**Our Case Number:** ABP-314724-22

**Re:** Railway (Metrolink - Estuary to Charlemont via Dublin Airport) Order [2022]  
Metrolink. Estuary through Swords, Dublin Airport, Ballymun, Glasnevin and City Centre to  
Charlemont, Co. Dublin

**A SUBMISSION IN RESPECT OF THE RAILWAY (METROLINK-  
ESTUARY TO CHARLEMONT VIA DUBLIN AIRPORT) ORDER  
2022, - WITH SPECIFIC REFERENCE TO THE PROPOSED MATER  
STATION AND ASSOCIATED TUNNEL.**

**MADE ON BEHALF OF EAMONN SMYTH, 13 NELSON STREET,  
PHIBSBOROUGH, DUBLIN 7, AND DATED 4<sup>TH</sup> JANUARY 2023.**

MATER STATION

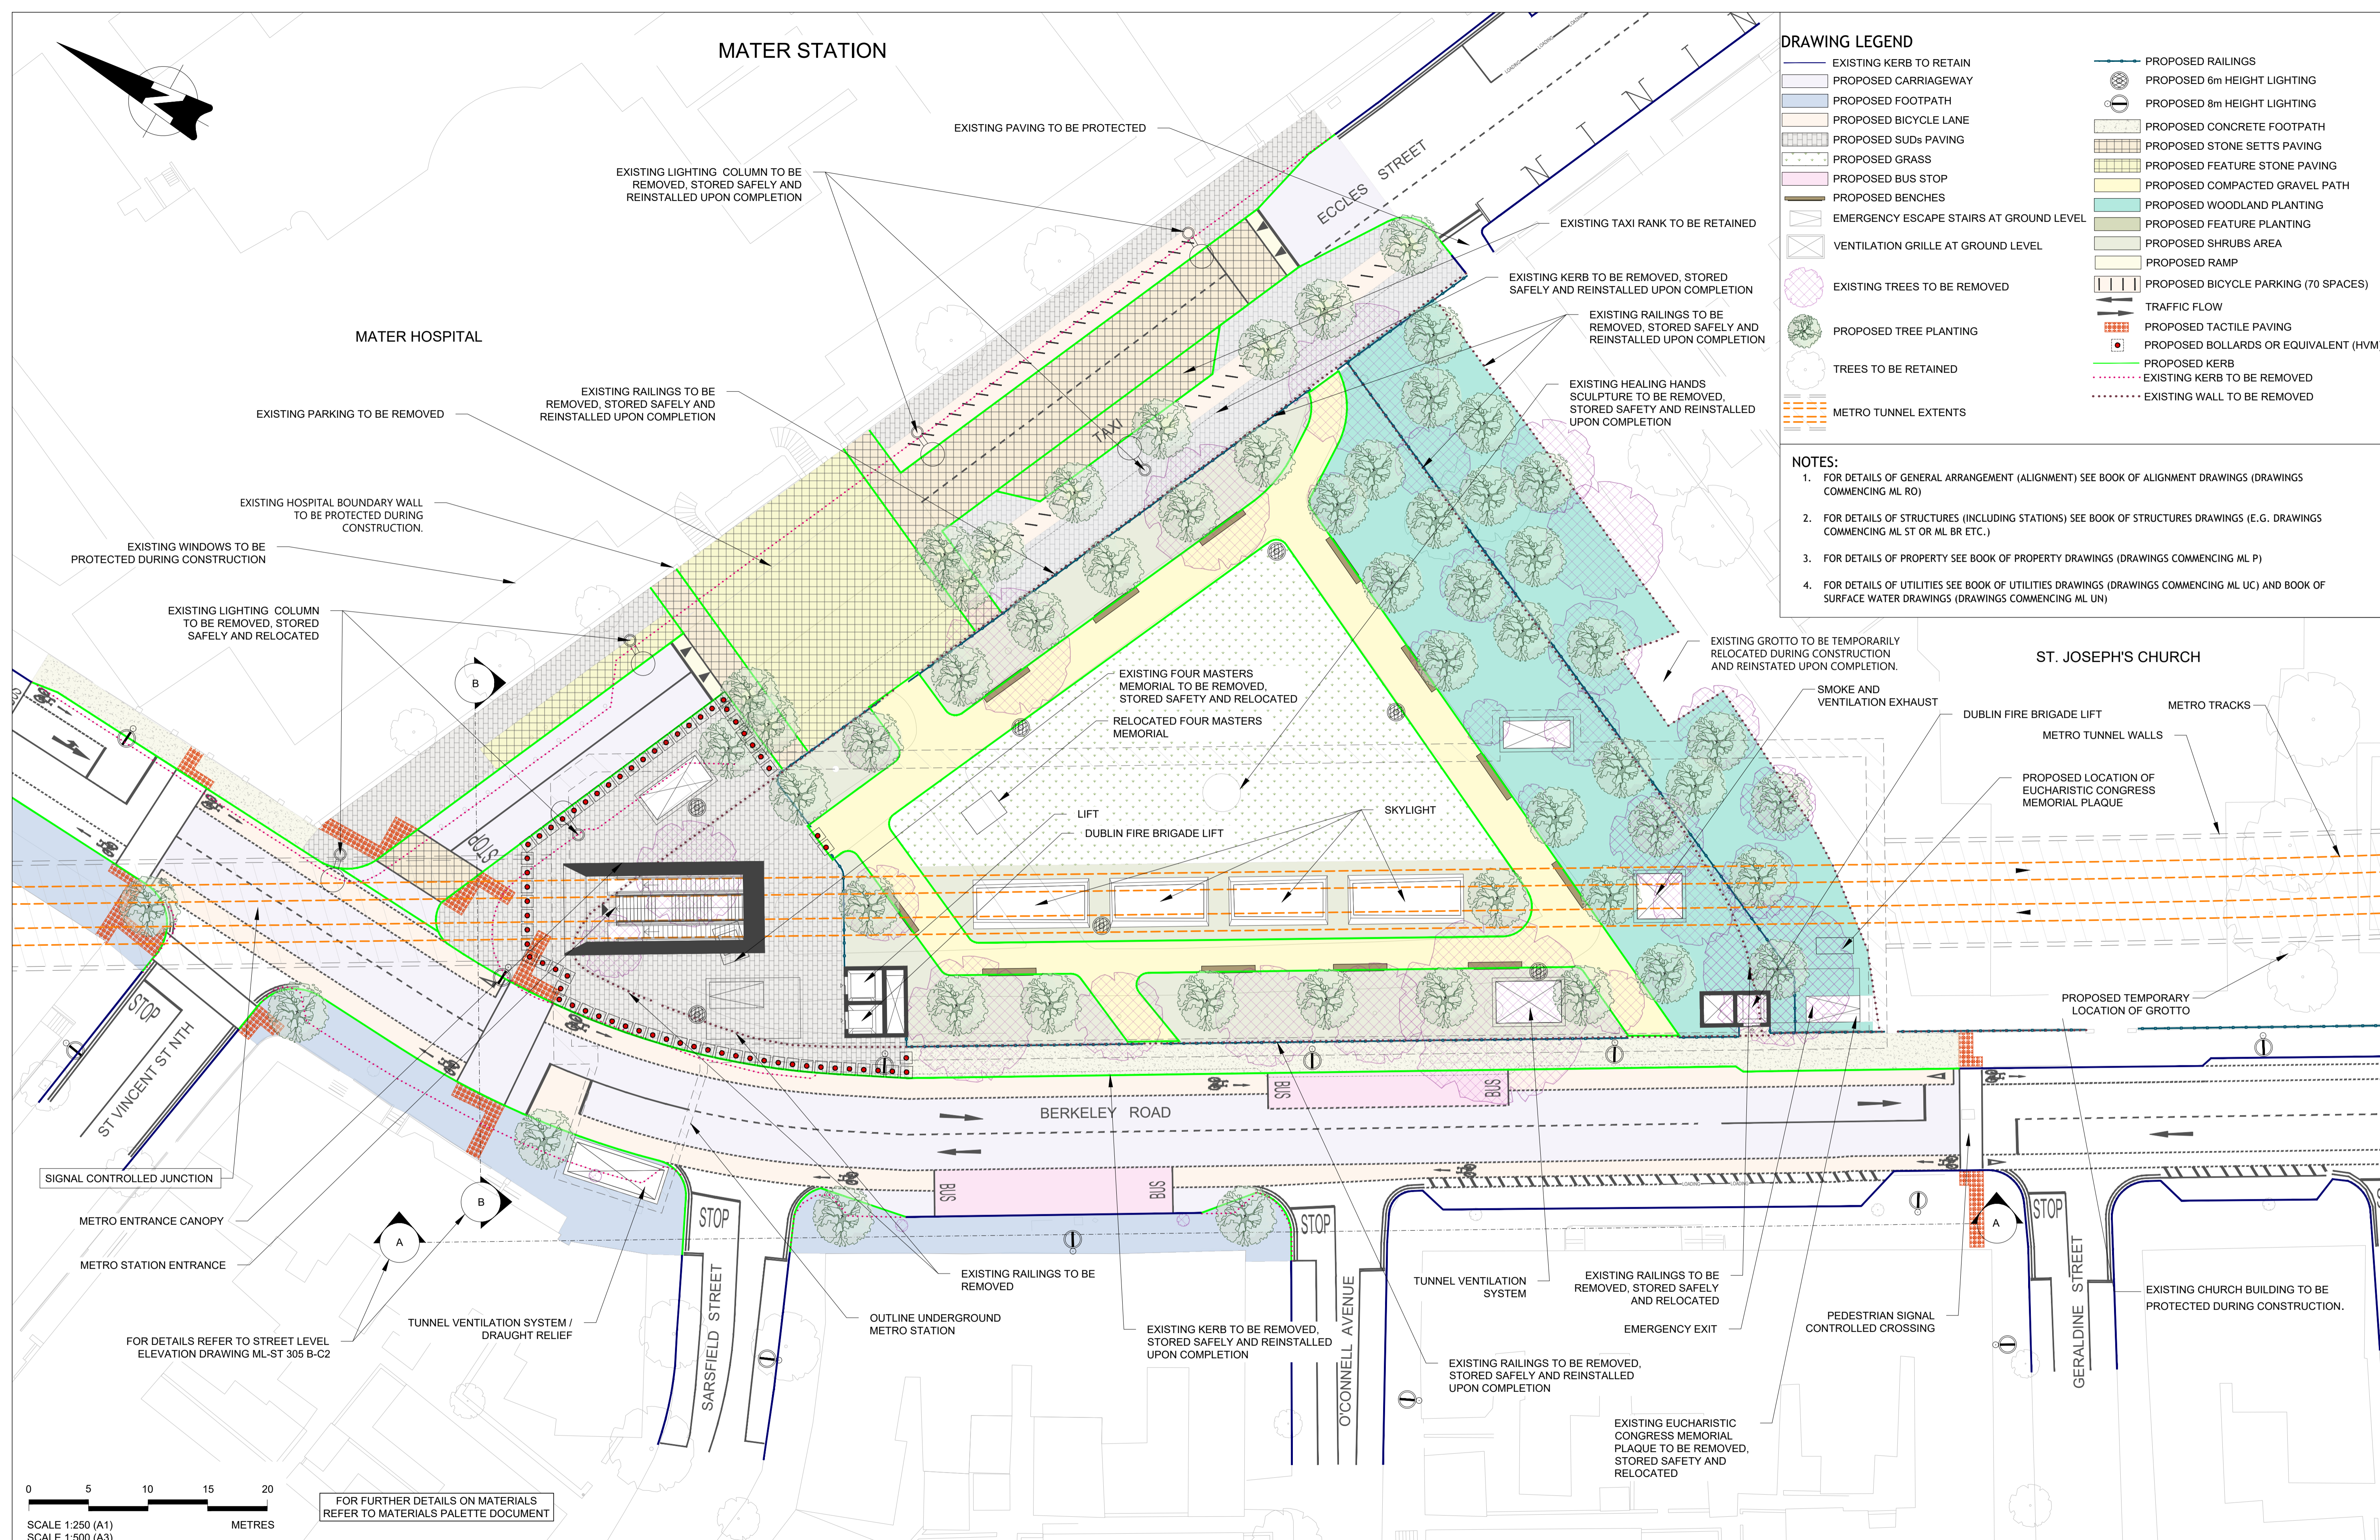
The proposed Station works as defined and authorised by this Order ('the Works'), will have significant consequences for the Four-Masters Park (the 'Park') located on the corner of Berkeley Road and Eccles Street. This park is focally dominant in the area and is a welcoming sight for residents and visitors alike, particularly those who enter the area from the North Circular Road/Berkeley Road direction. It has been indicated by Metrolink, that on completion of the Works, the original Park would be reinstated, but only in so far as possible. Such language is meaningless and limitless in the context of the Station and the Park. And the proposed design of the Station lends credence to this assertion.

I would argue that the small triangular corner of the Park, which contains the Four Masters Cross, is the most focally dominant and visually pleasing section of the Park. Therefore, if this small triangular corner (which is bounded by Berkeley Road and Eccles Street on two of its sides) was retained/restored as is, and the remaining boundary of the triangle screened off from the Station entry/exit point, (by suitable trees, for example) this would go some way towards retaining the visual impact of this very important focally dominant section of the Park, for this area.

In order to achieve this objective, the orientation of the proposed entry/exit point of the Station should be altered [rotated] by ninety degrees, so that it would face the old Mater Hospital portico on Eccles Street.

In addition, the design and finish of the Station together with its proposed location, the finish of the emergency exit, and other associated structures along the Berkeley Road frontage, is not in keeping with the surrounding architecture – the Mater Hospital, St Joseph's Church, and terraced houses along Berkeley Road/Street. This requires to be addressed in consultation with local residents.
